From: Chris Moore
Sent: 24 June 2020
To: Sian Eggington
Cc: 'Shaun Taylor'
Subject: FW: Request for further information P/55/20/HH
Attachments: We sent you safe versions of your files; P_55_20_HH20200624100991570.pdf; Garage Detail.pdf; Site Plan 500.pdf; Location Plan.pdf

Block Plan: Please submit a proposed block plan with dimensions to all site boundaries. – The new garage completely fills the available plot size so no distance to boundaries – I have put a note in RED on the site plan.

GROUND FLOOR PLAN

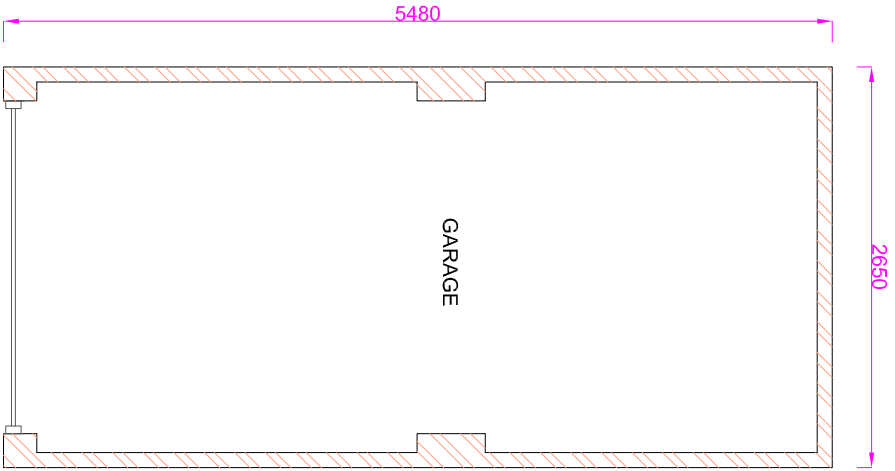
Room Labels: You are required to have room labels on all floor plans. Please amend. – Amended.
